Application for a Non-Material Amendment Following a Grant of Planning Permission

Site to southern end of Salt Box field, defined as 'Unit 9' within larger hybrid application

BE/135/18/PL

Non-Material Amendment(s) Sought

Client	Richmond Motor Group
Project	Salt Box Site, Bognor Regis
Title	Proposed First Floor Plan

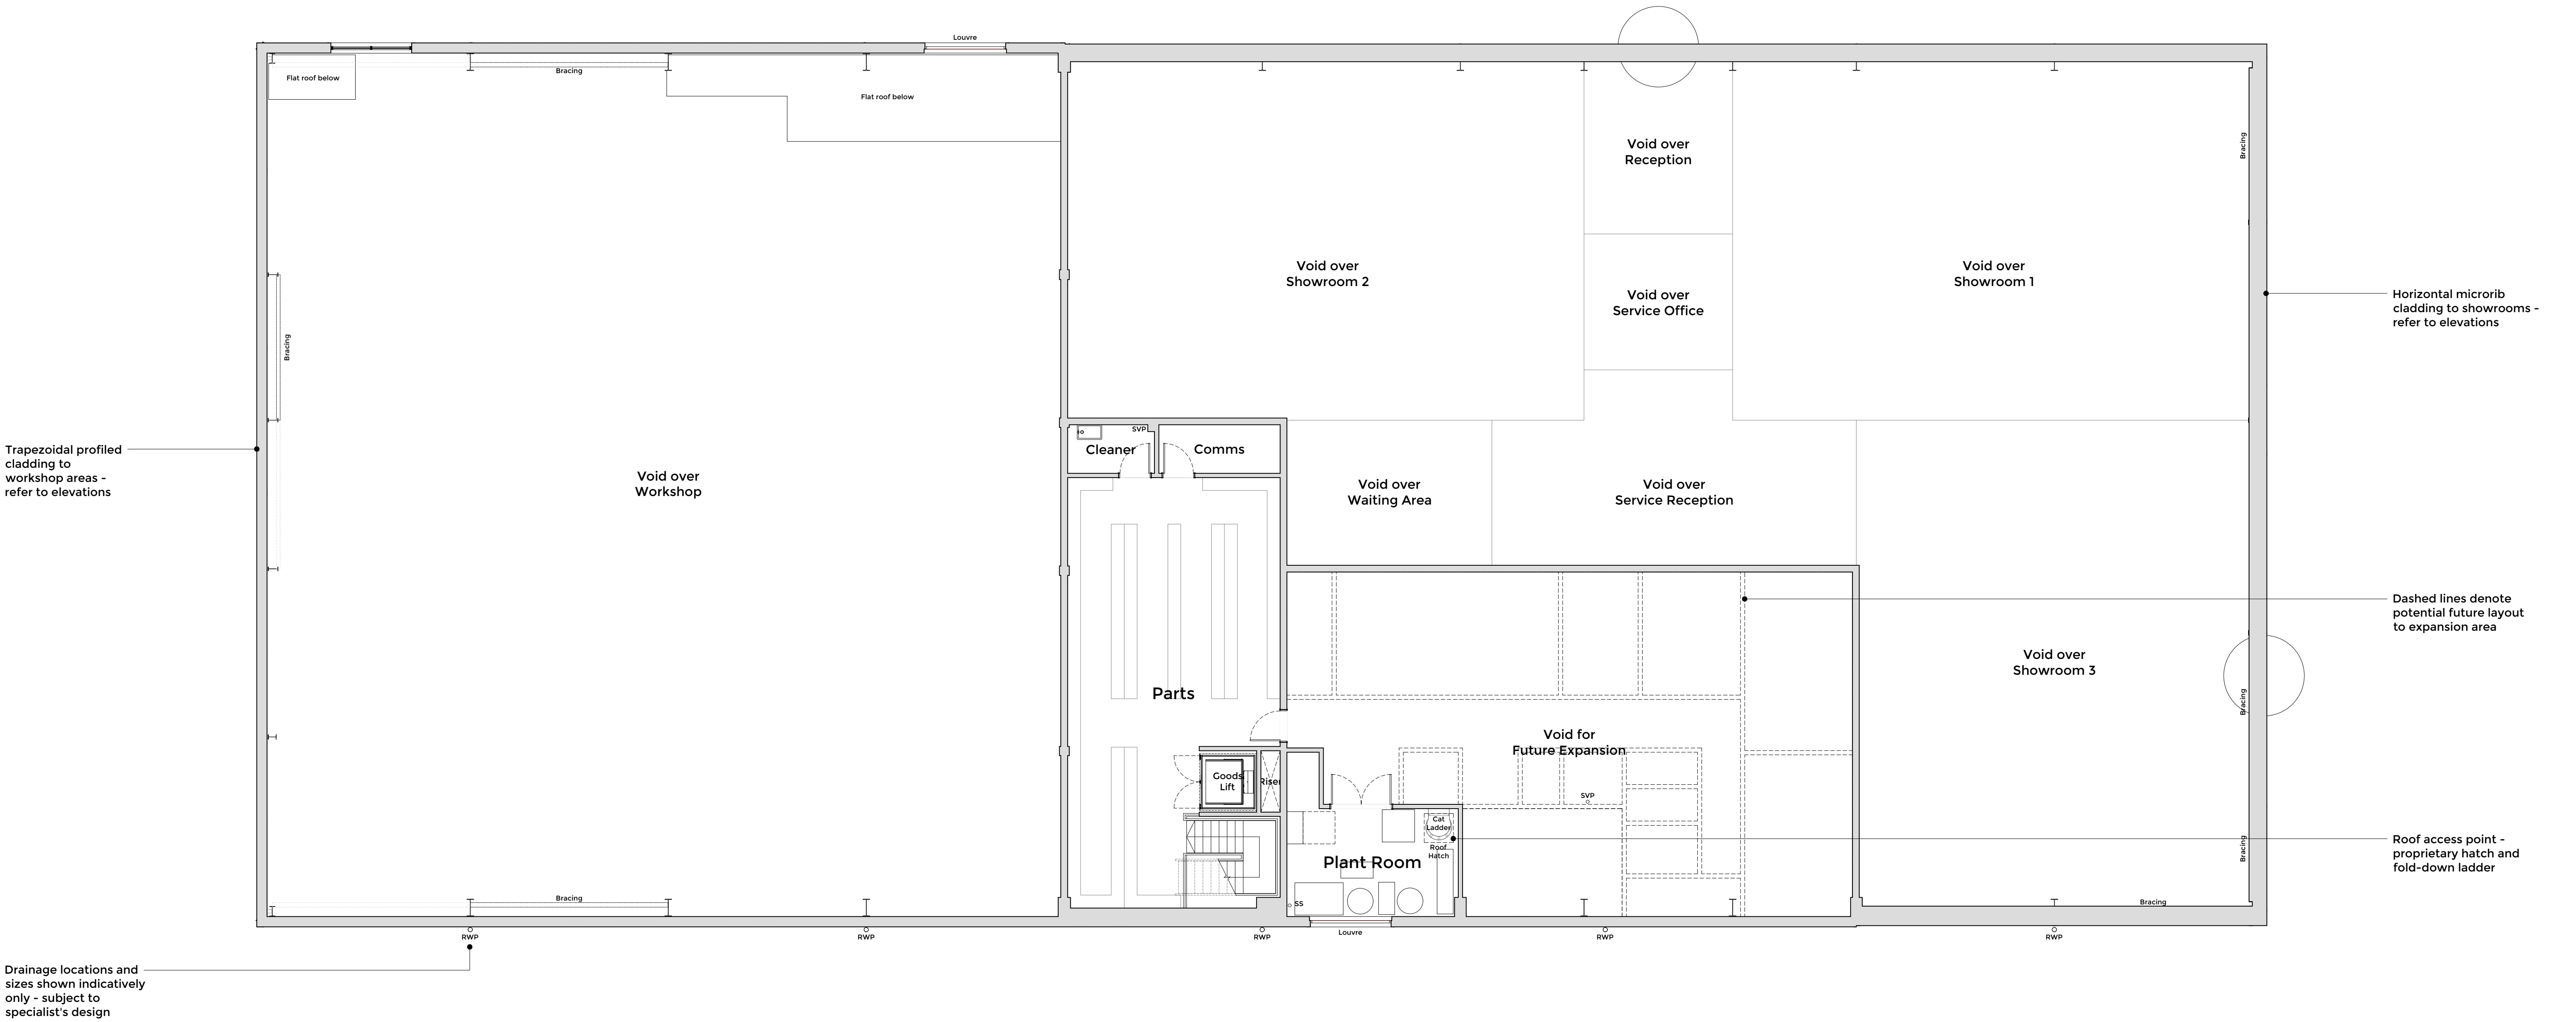
- Building depth reduced by c. 3.5m
- Roof profile changed - now monopitch rather than portal frame
- Roof material amended (now single ply to suit low pitch roof) and rooflights omitted
- Vertical cladding shown to south elevation
- Additional fire exit door shown to south elevation
- 3no. revolving and 3no. accessible doors to showrooms omitted and replaced with 2no. bi-parting 'drum' doors
- Curtain walling layout updated to reflect the above
- 1no. high-level fixed window (north elevation) changed to louvre serving workshop
- Louvre shown to plant room (south elevation)
- Internal layout amended to client's requirements; remainder of mezzanine now shown as expansion space
- Dry Valet and Wet Valet buildings combined; vertical cladding shown to south elevation
- External areas updated to suit

- Building depth reduced and internal layout amended to reflect efficiencies made with remote working, number of staff required on site, etc - majority of first floor is now reserved for potential future expansion

Client	Richmond Motor Group
Project	Salt Box Site, Bognor Regis
Title	Proposed Valet Building

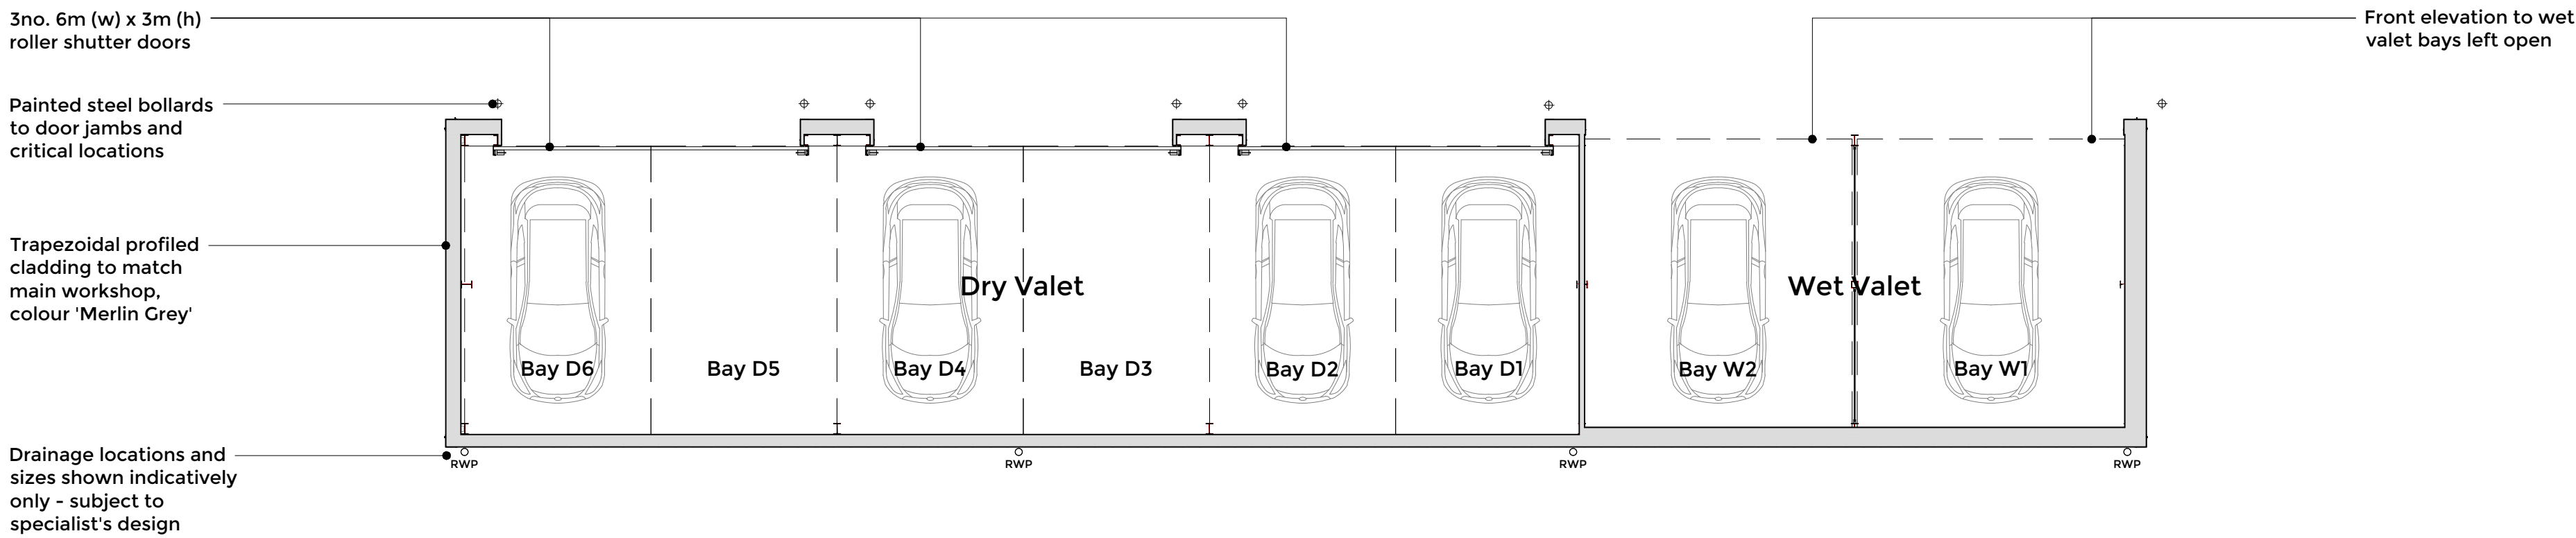
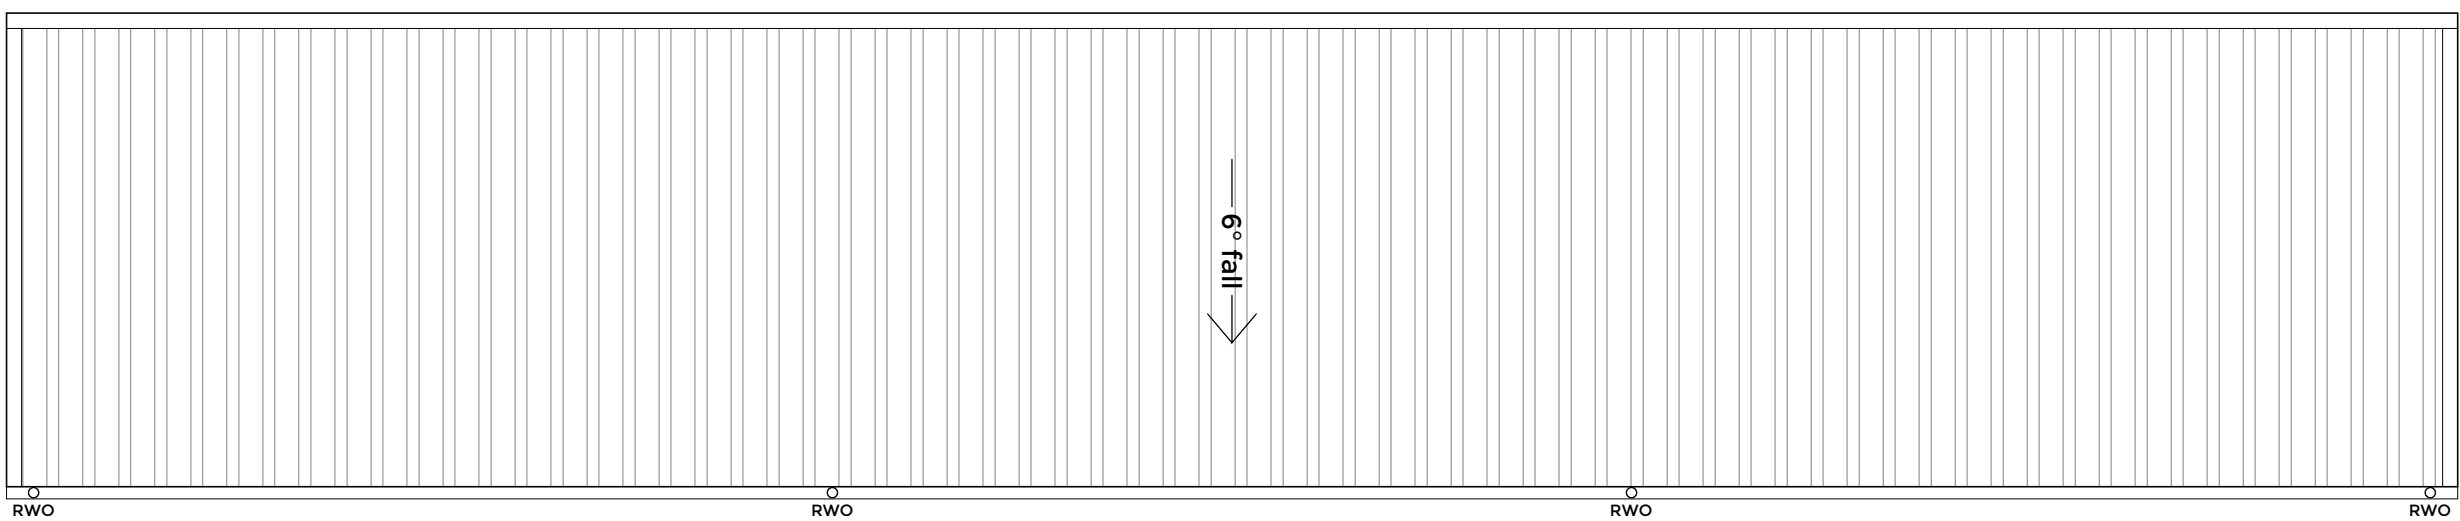
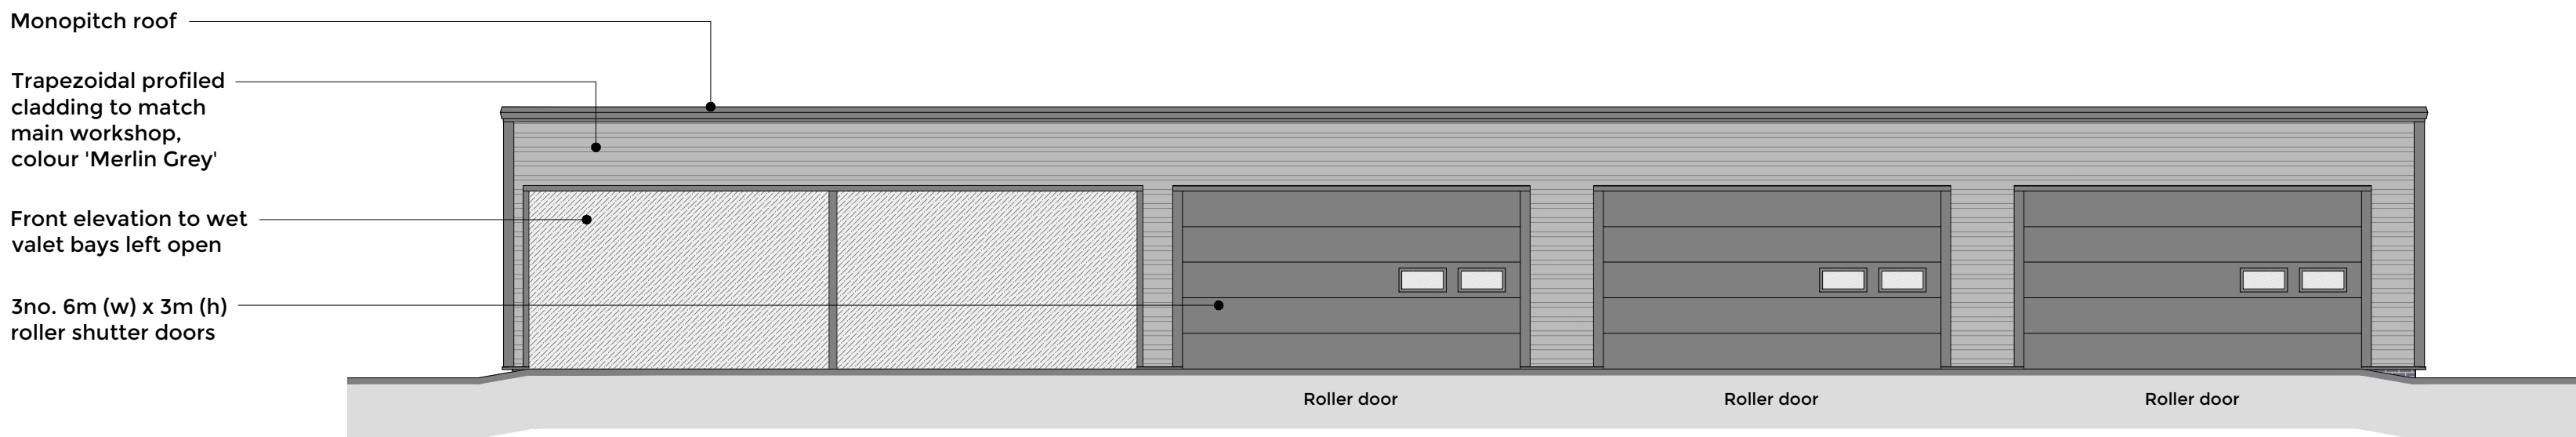
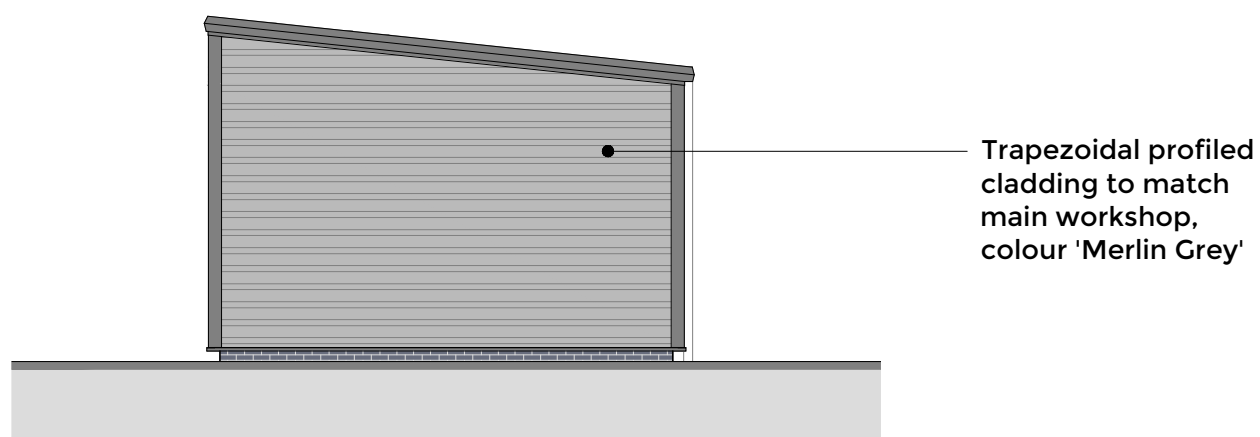
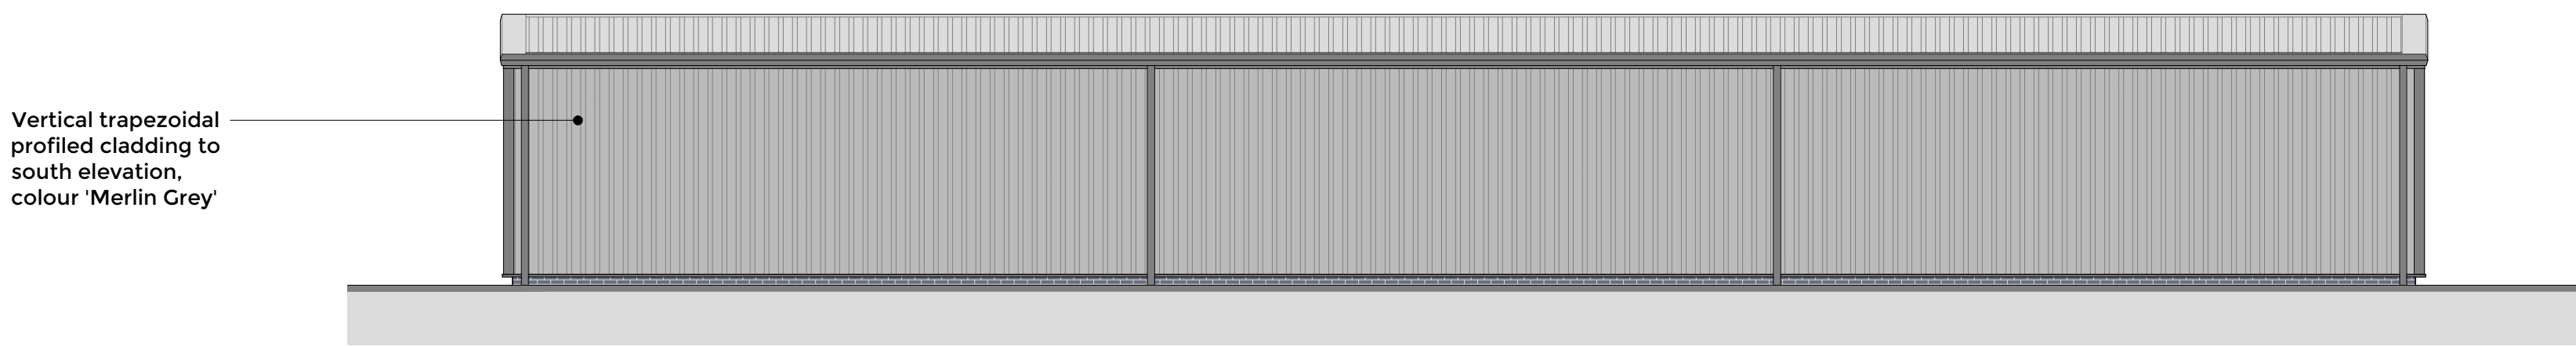
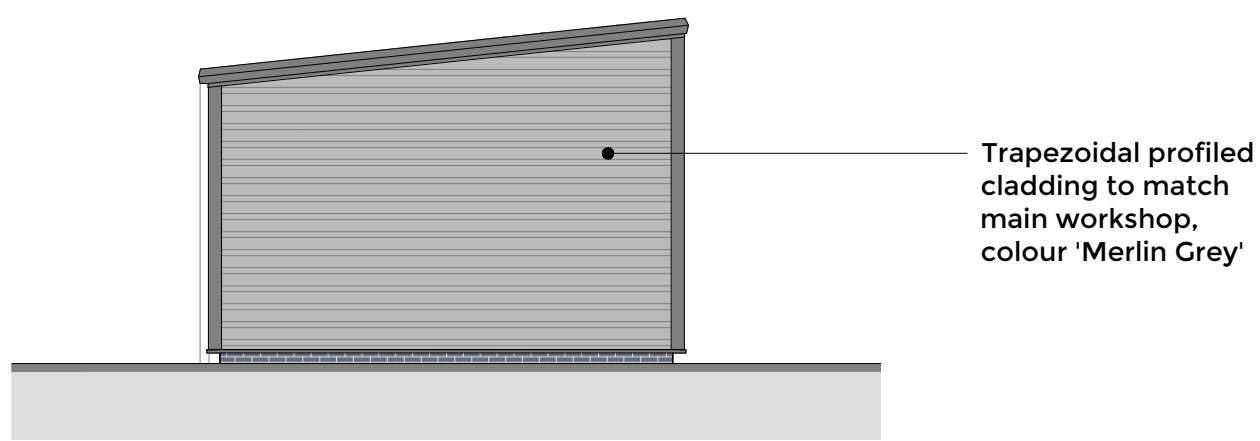
- 2no. louvres required to suit M&E design
- Valet buildings combined to suit client requirements and also provide better shielding of activities from south of the site
